Case Officer: Shona King

Recommendation: Approve

Proposal: Erection of two dwellings with associated garaging, alterations to garaging and boundary wall to dwelling approved under 18/01914/F and 18/01915/LB

**SITE PLAN**  
(Scale 1:200)

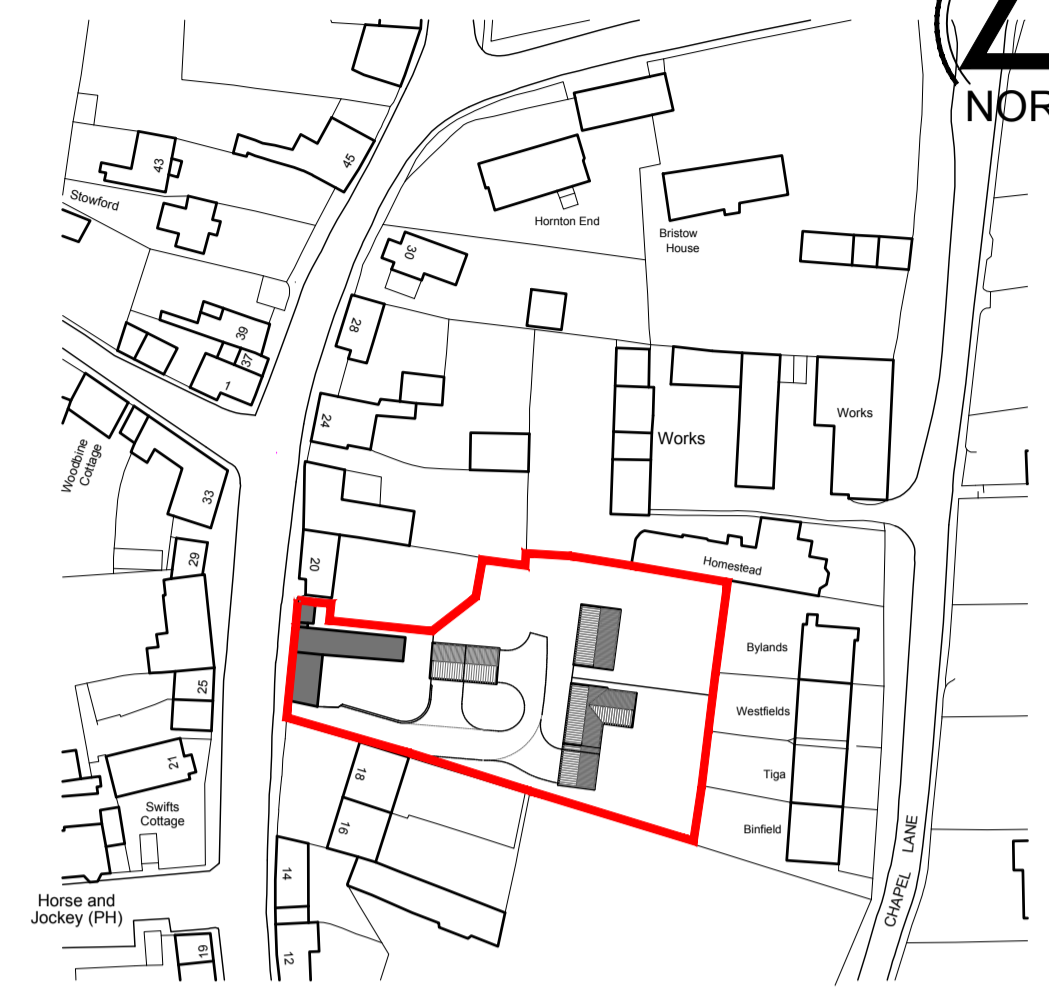
- 8.13. The application proposal has been amended to reposition the dwellings and the garages to reduce the potential impact of the proposals on the neighbouring properties and to try to create a more compact built form enabling more of the open space to remain. The garages for the barn conversion and Plot 2 have also been adjoined and located in a similar position to that approved under 18/01914/F.

- 8.27. The dwelling to the north of the site, The Homestead, forms part of the northern boundary. There are habitable room windows in the south elevation of that property at both ground and first floor. The application proposals have been amended to seek to preserve the privacy of the occupiers of the neighbouring property with the addition of a 1.8m high wall surrounding a 4m x 3m space adjacent to the ground floor window in the southern elevation of The Homestead. It is considered that this is sufficient to prevent users of the garden of Plot 2 being able to look into this ground floor window. The siting of Plot 2 has also been amended, moving it further to the south away from the northern boundary. This was required as the original position would have resulted in the unacceptable loss of light to the ground floor habitable room window and private amenity space to the rear of The Homestead.

was substandard in terms of visibility onto the highway and that the drive serving the dwellings was too narrow to enable vehicles to pass. The application proposals have been amended to increase the width of the drive within the site and additional information has been provided in terms of a speed survey, a drawing showing the achievable visibility splays at the junction and a Transport Statement.

- 8.31. There does remain a slight risk of vehicles not being able to pass one another in the narrow entrance but, again, this is not unlike other accesses locally and in similar, village locations. It is most likely that the vehicle exiting would reverse within the site to allow the other vehicle to enter, and the site plan shows that this would not be too difficult.

9. Prior to the first occupation of Plot 2 the 1.8m high wall surrounding the window in the south elevation of The Homestead, shown on drawing No. 001 C, shall be constructed prior to the first occupation of Plot 2 and the wall shall be retained and maintained at that height thereafter.

Scale 1:50 @ A1
Date Aug 2019
Dwg No 003B

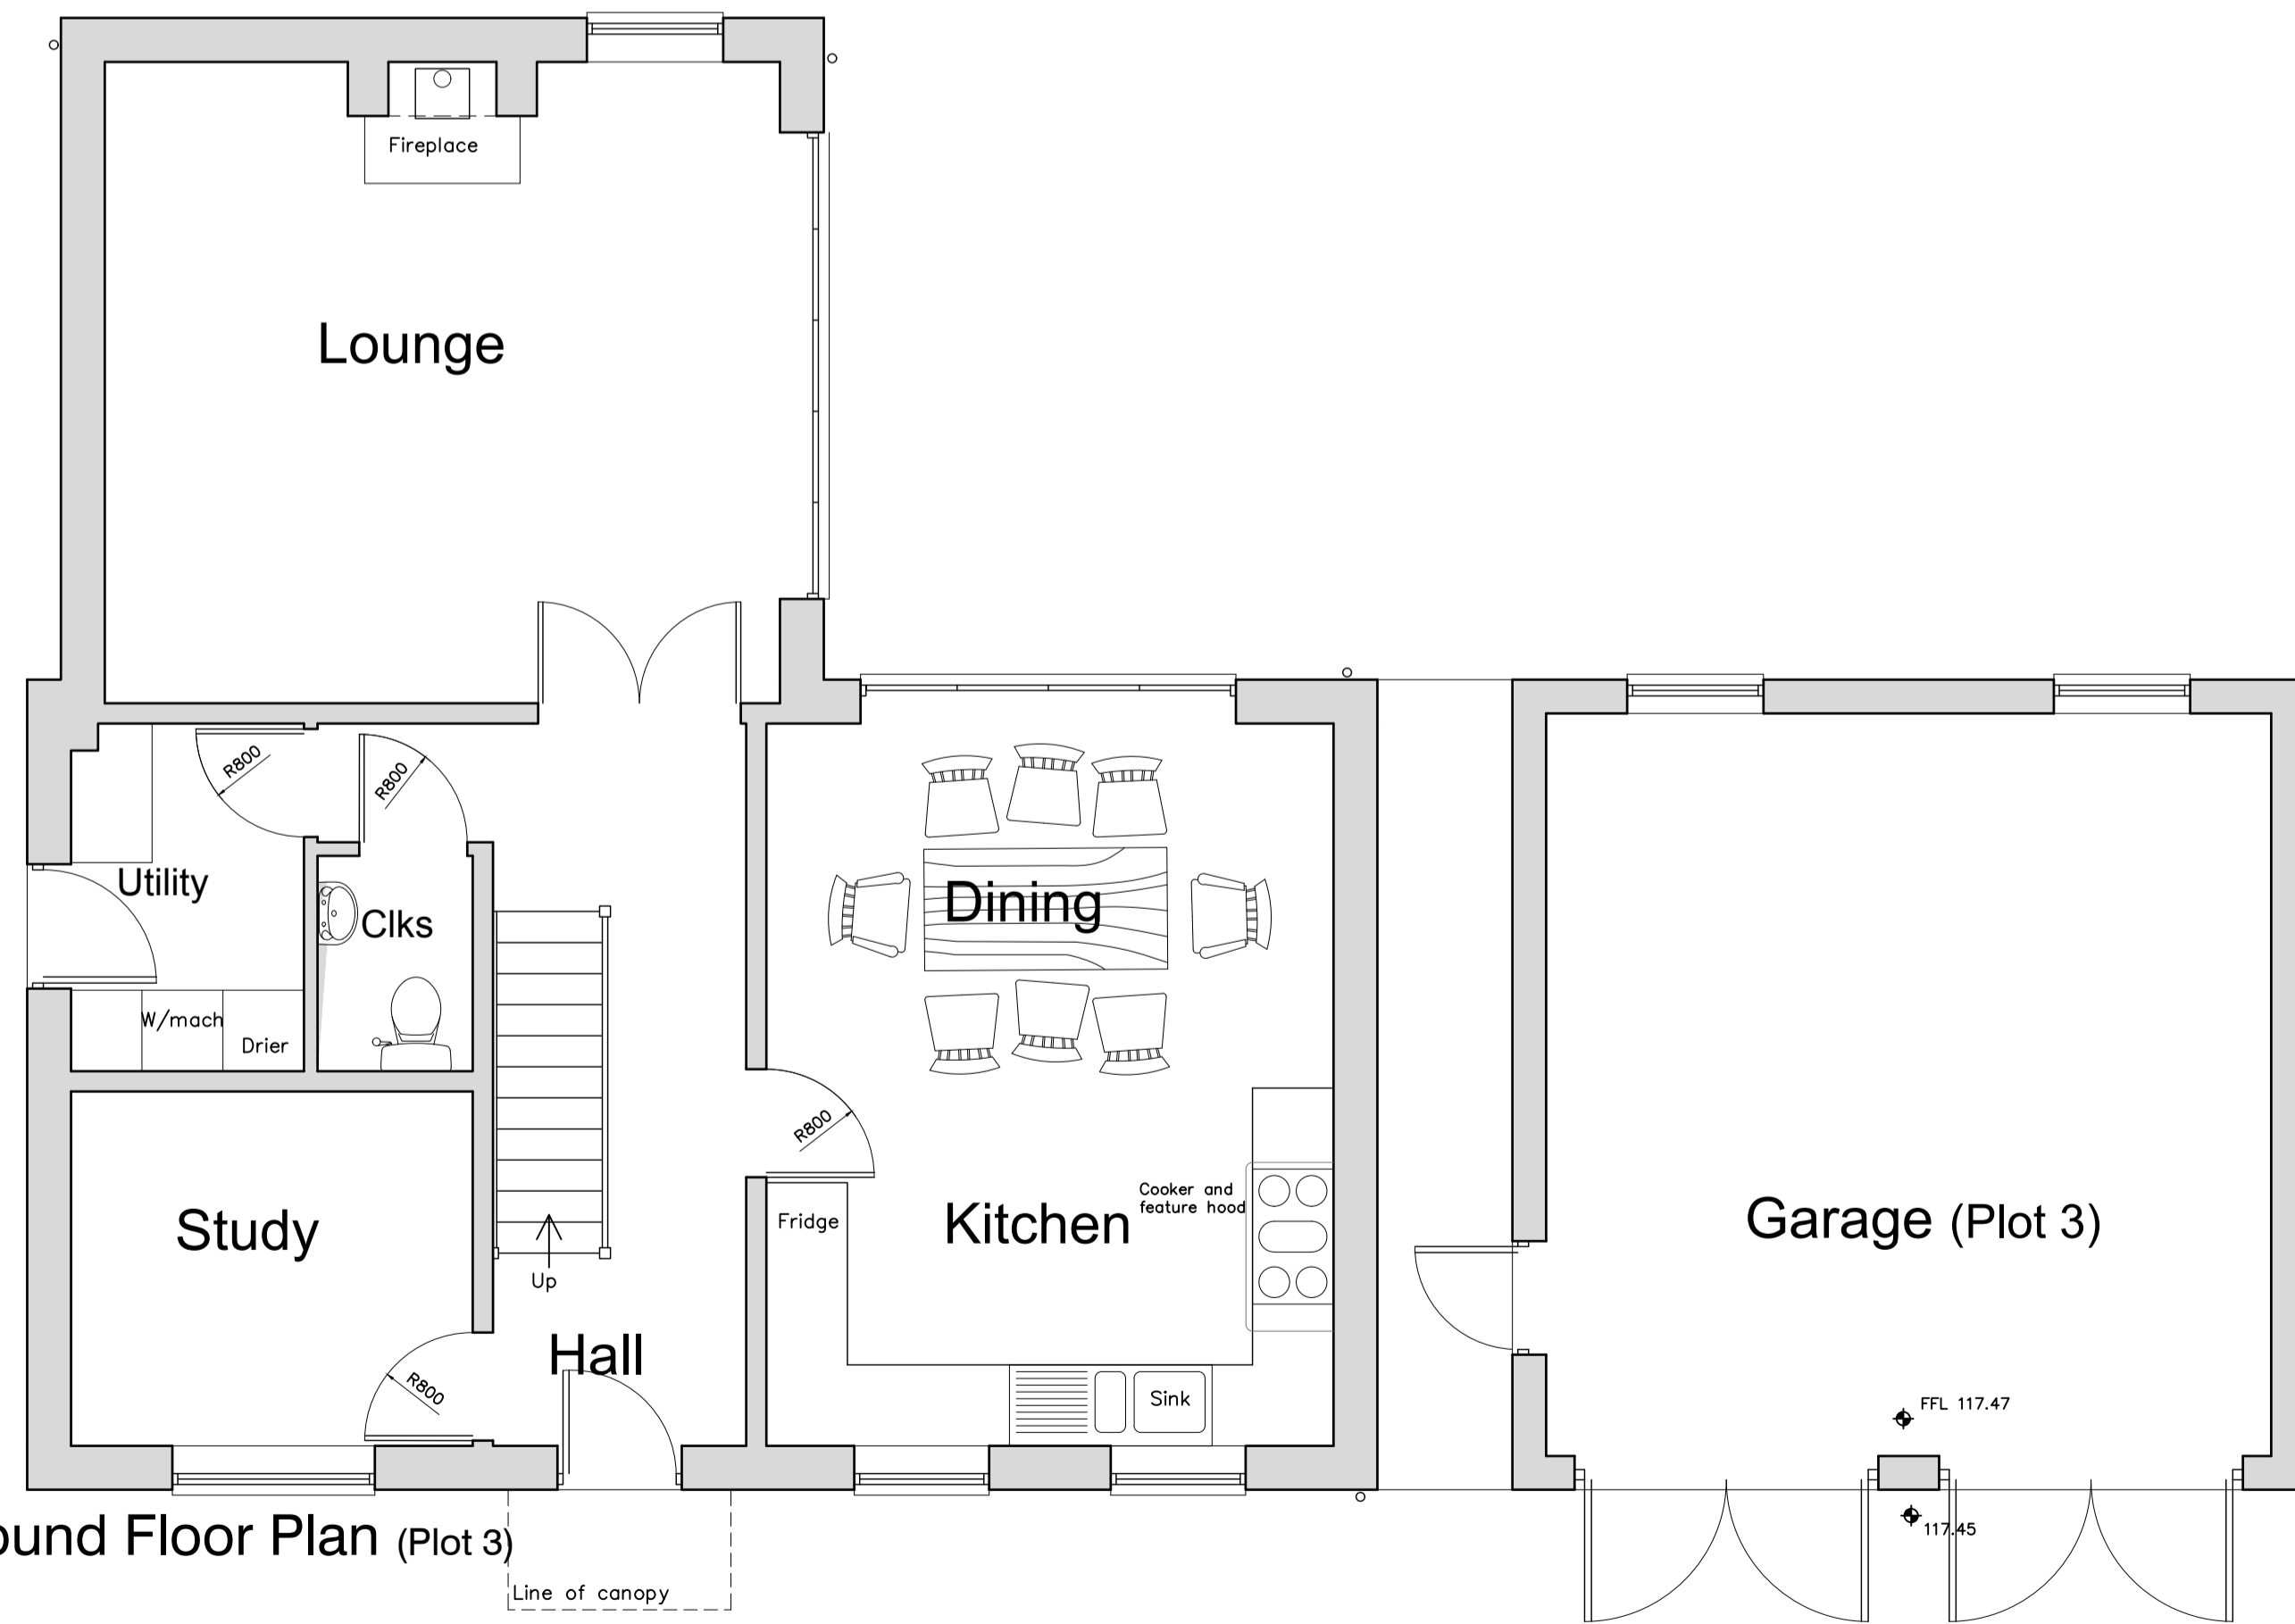
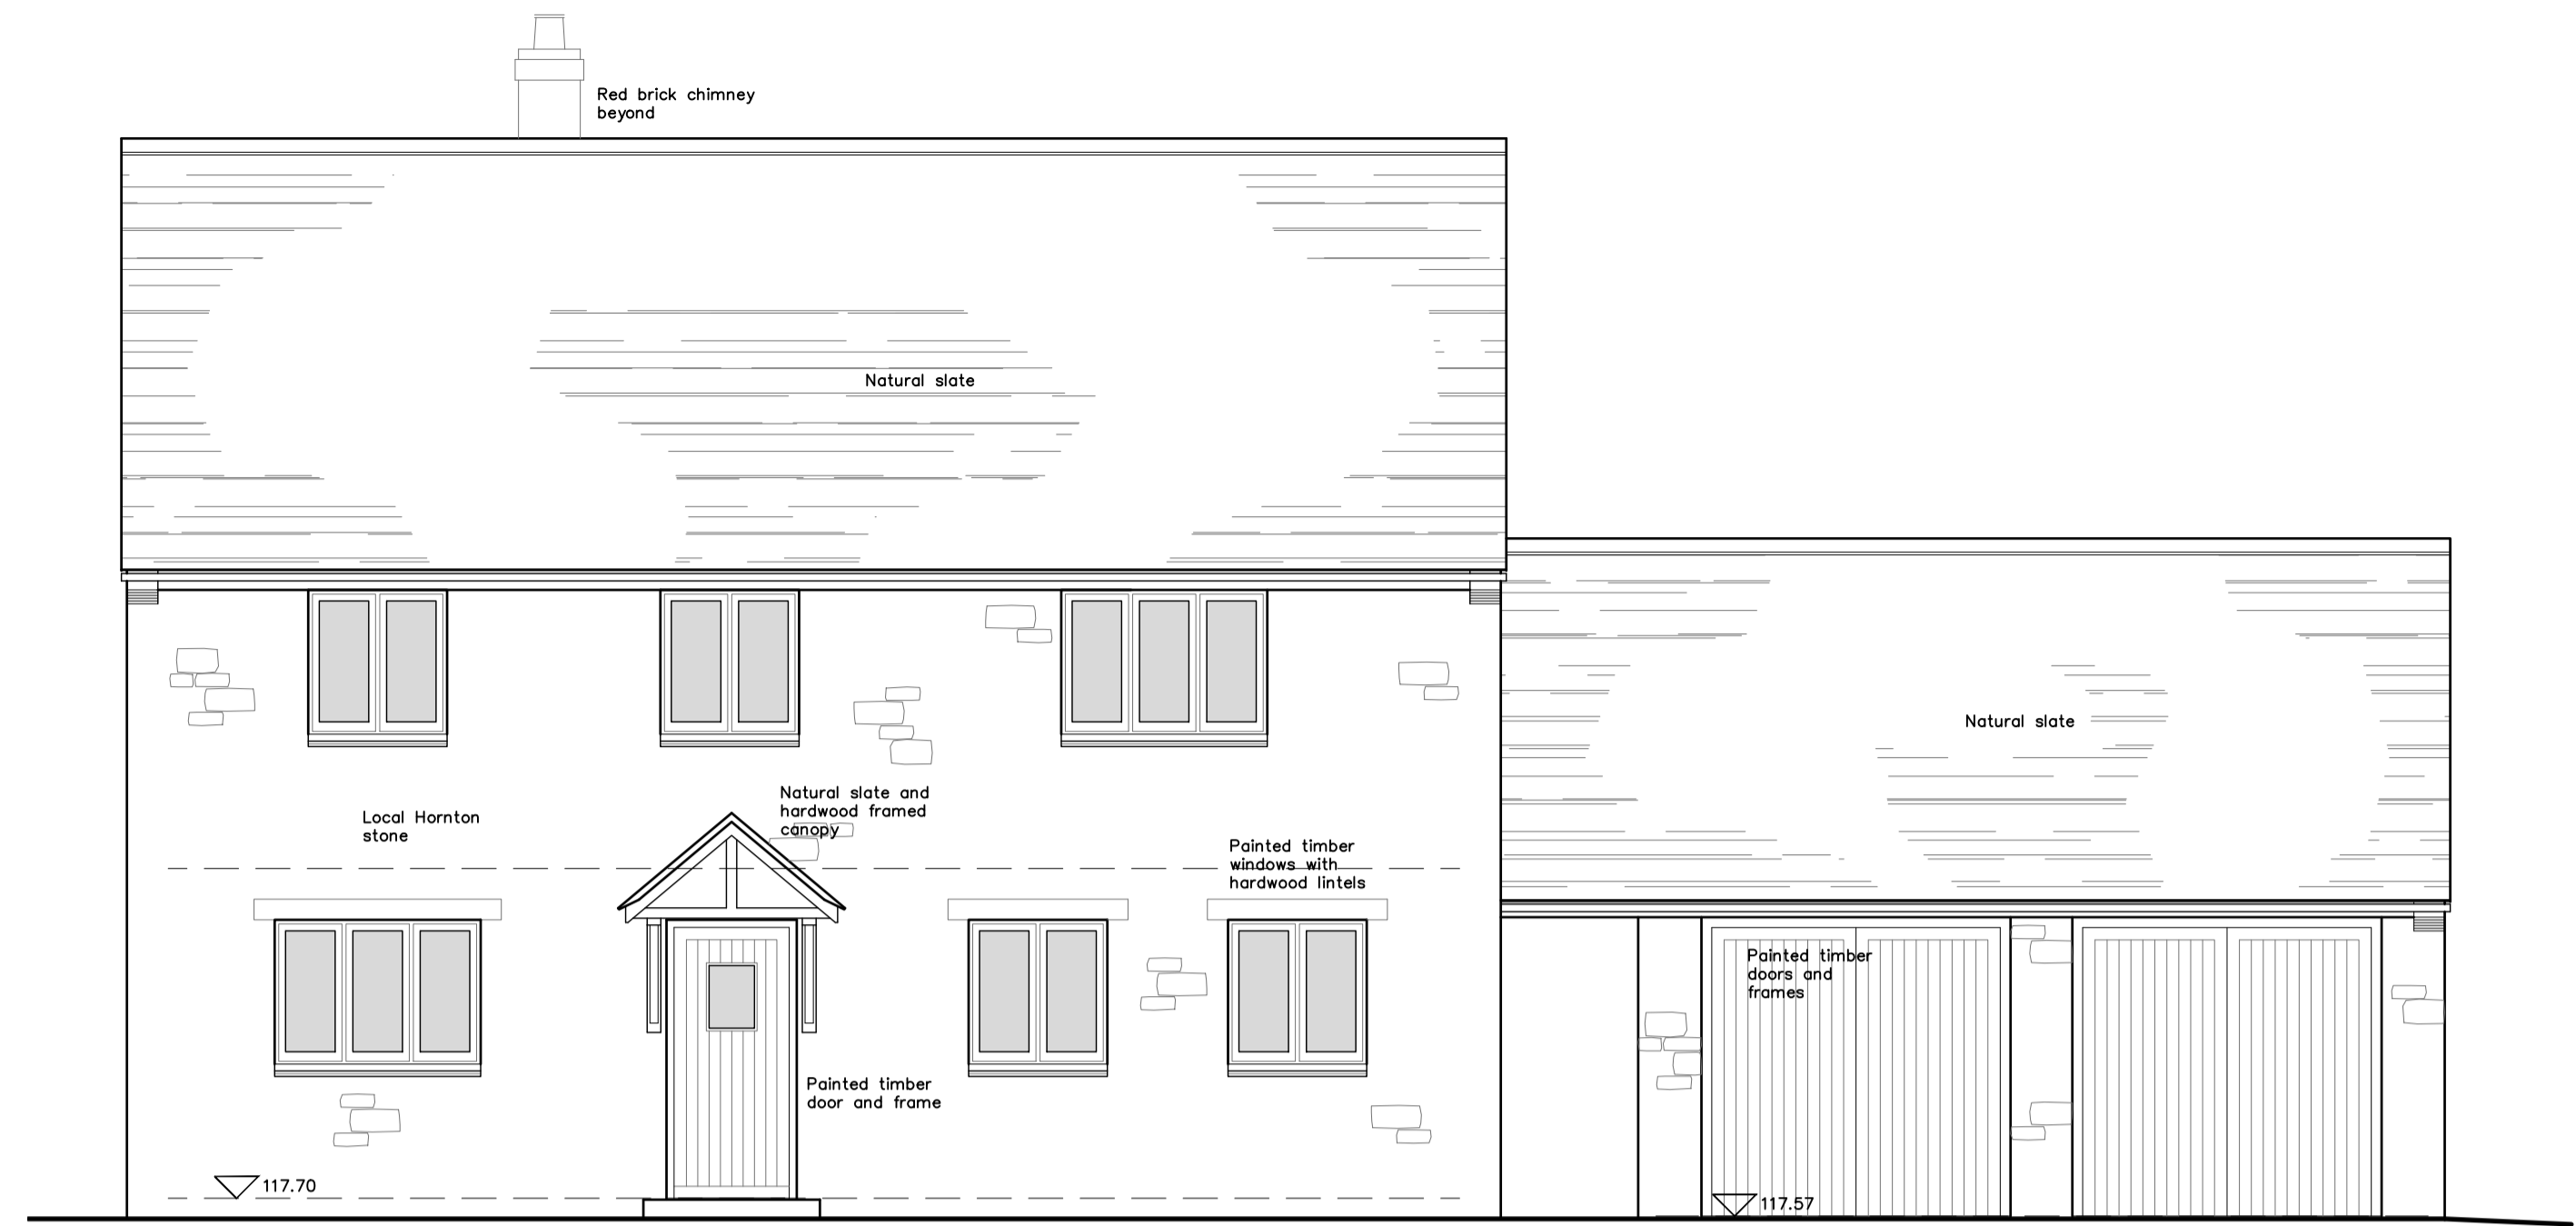
- 8.26. There is a side facing window proposed in the first floor of Plot 3 (south elevation) which is approximately 14m from the shared boundary with the garden of The Manor House. It is considered that given the distance to the boundary and the height of the boundary wall there would not be any significant increase in overlooking particularly as there is an existing first floor window in the south elevation of the terrace of dwellings to the east of the application site which is very close to the boundary of this garden.
